Application No: 10/01780/HYBRID	Ward: Caversfield	Date Valid: 23/12/2010
---	--------------------------	----------------------------------

Site Address:	Bicester Eco Town Exemplar Site Caversfield Oxfordshire
----------------------	---

Proposal: Development of Exemplar phase of NW Bicester Eco Town to secure full planning permission for 394 residential units and an energy centre (up to 400 square metres), means of access, car parking, landscape, amenity space and service infrastructure and outline permission for a nursery of up to 350 square metres (use class D2), a community centre of up to 350 square metres (sui generis), 3 retail units of up to 770 square metres (including but not exclusively a convenience store, a post office and a pharmacy (use class A1)), an Eco-Business Centre of up to 1,800 square metres (use class B1), office accommodation of up to 1,100 square metres (use class B1), an Eco-Pub of up to 190 square metres (use class A4), and a primary school site measuring up to 1.34 hectares with access and layout to be determined.

Figure 3 – Bridge 1 & 2 Design Drawings

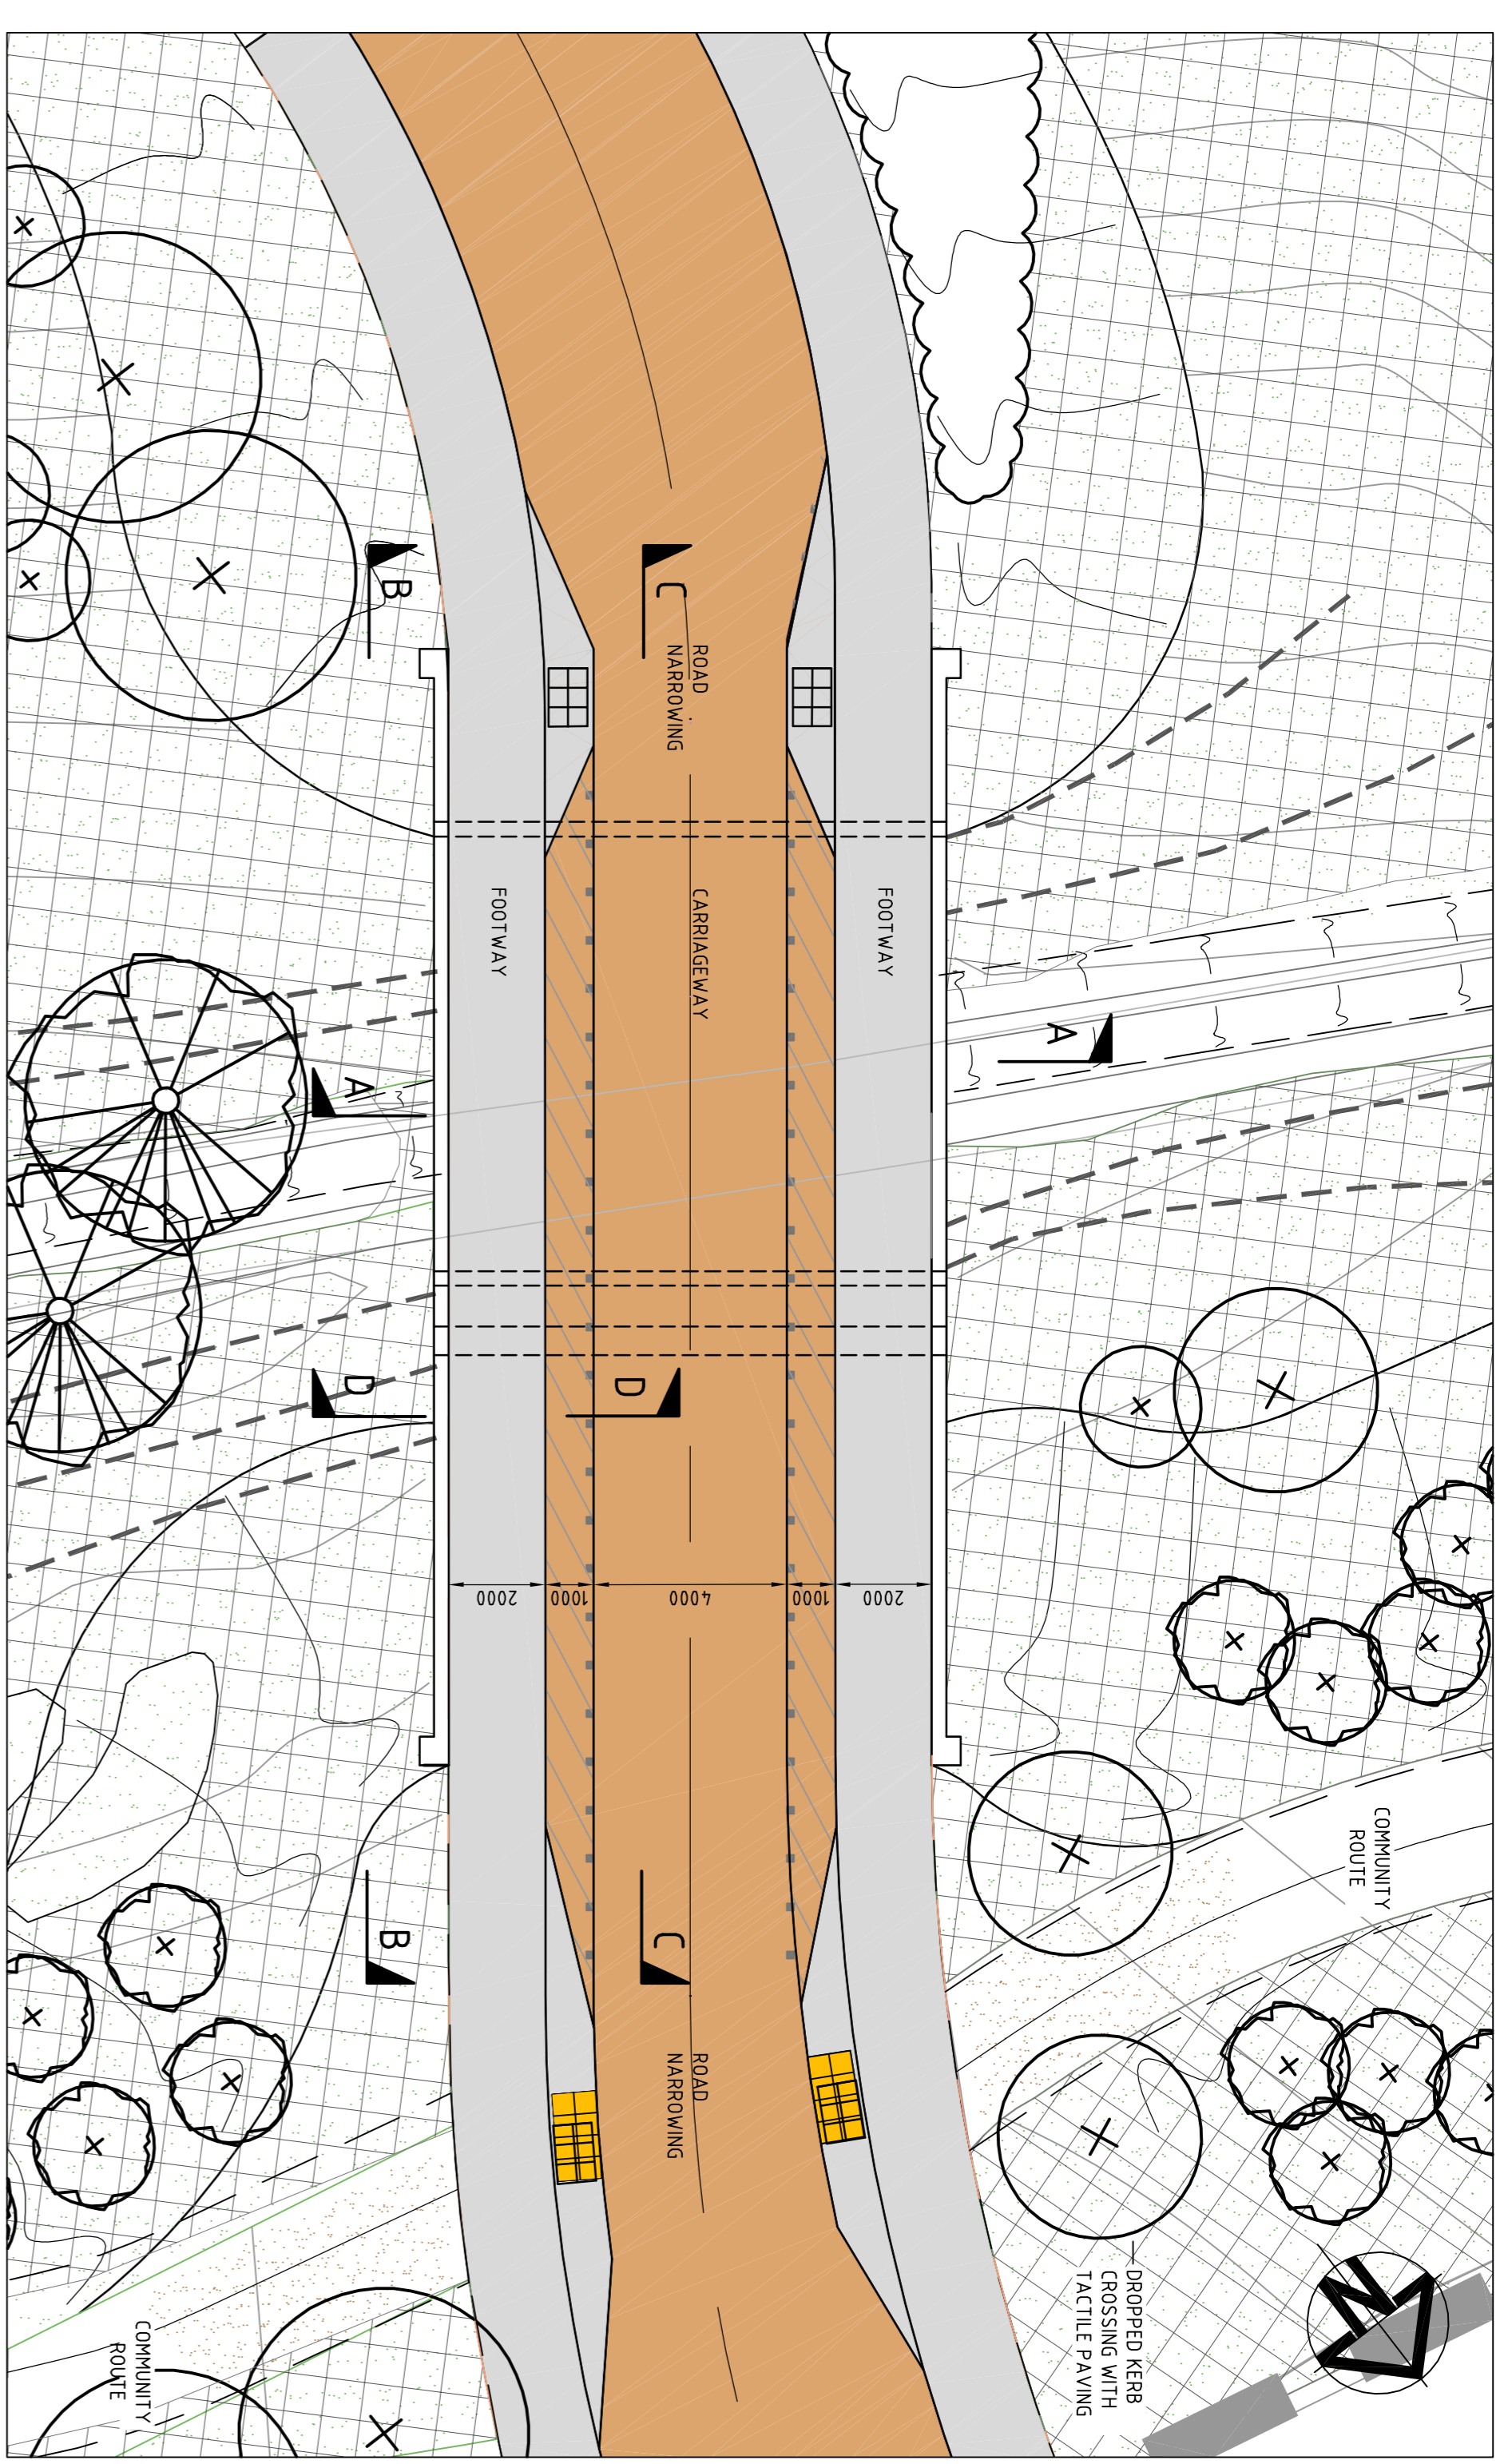
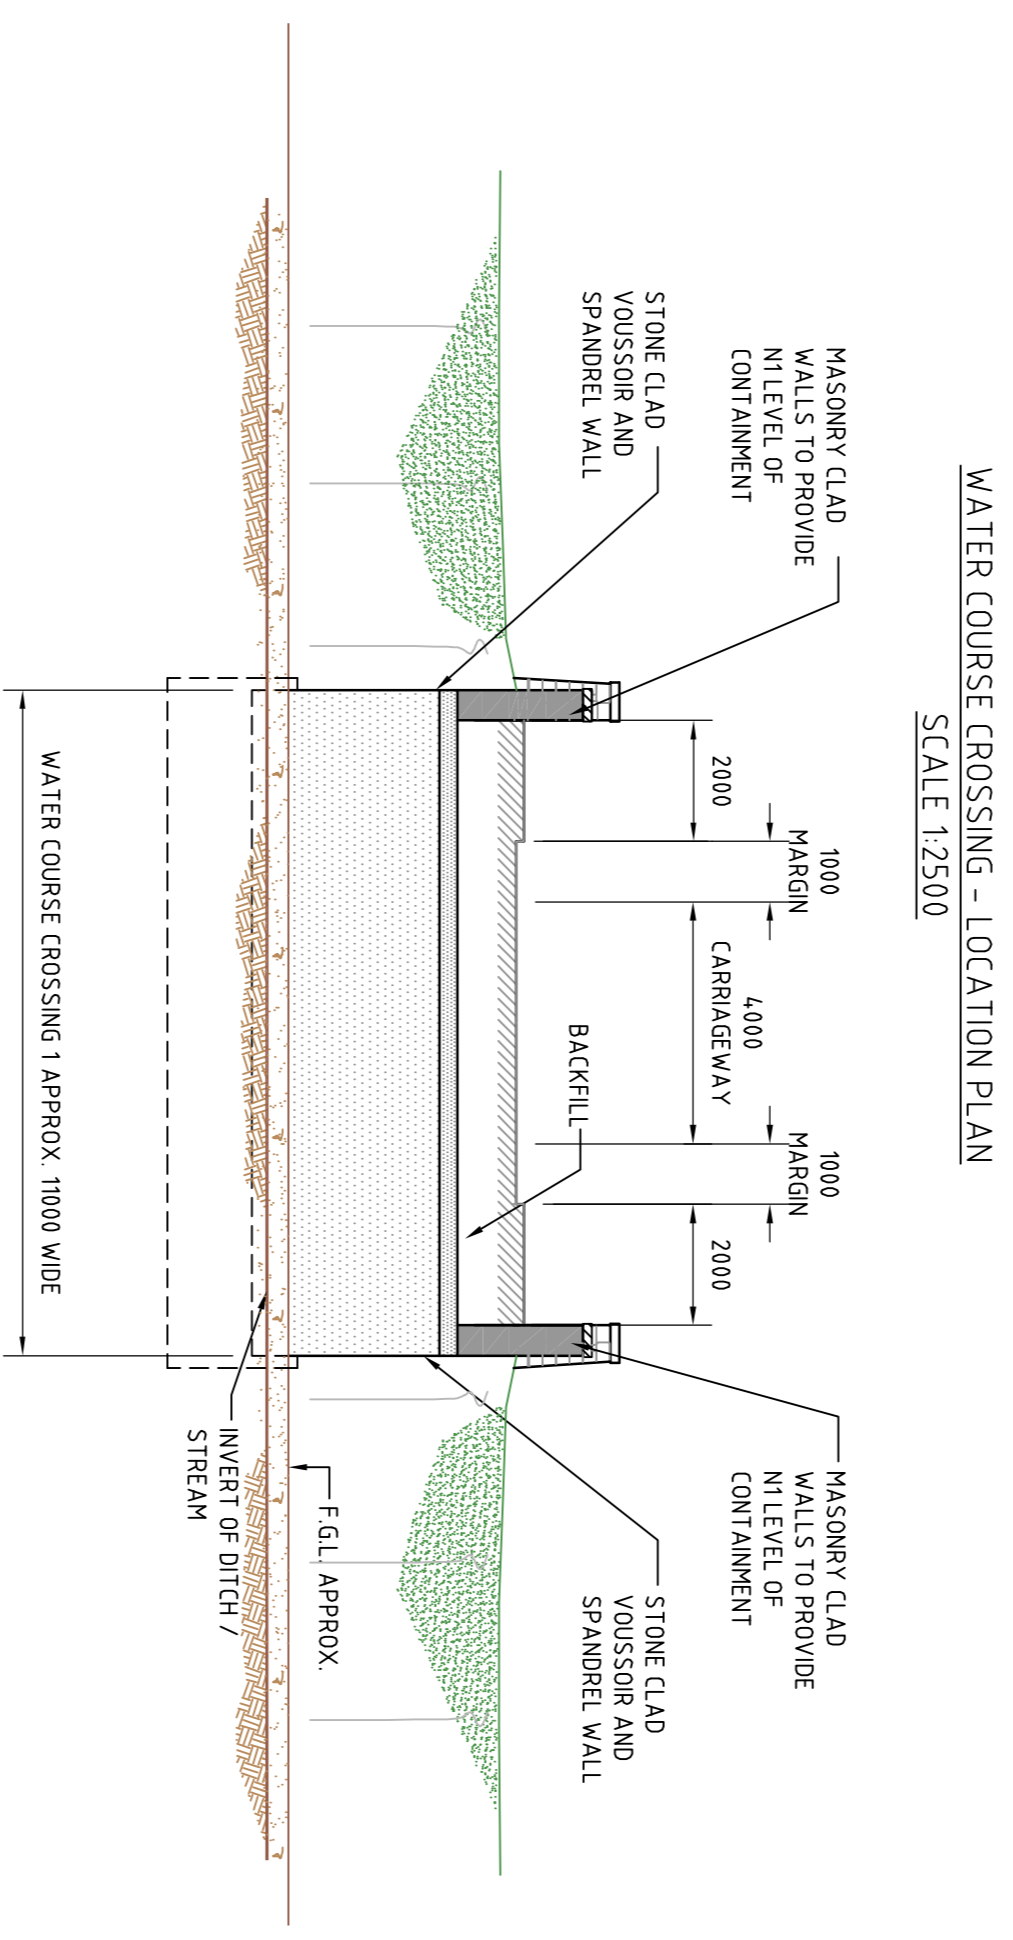
- The two bridges proposed within the site appear to be structurally sound, but the functional appearance is a missed opportunity to create an architectural statement that is exemplary in its design. Further details are required before “Approved In Principle” (AIPs) plans can be issued for their implementation.
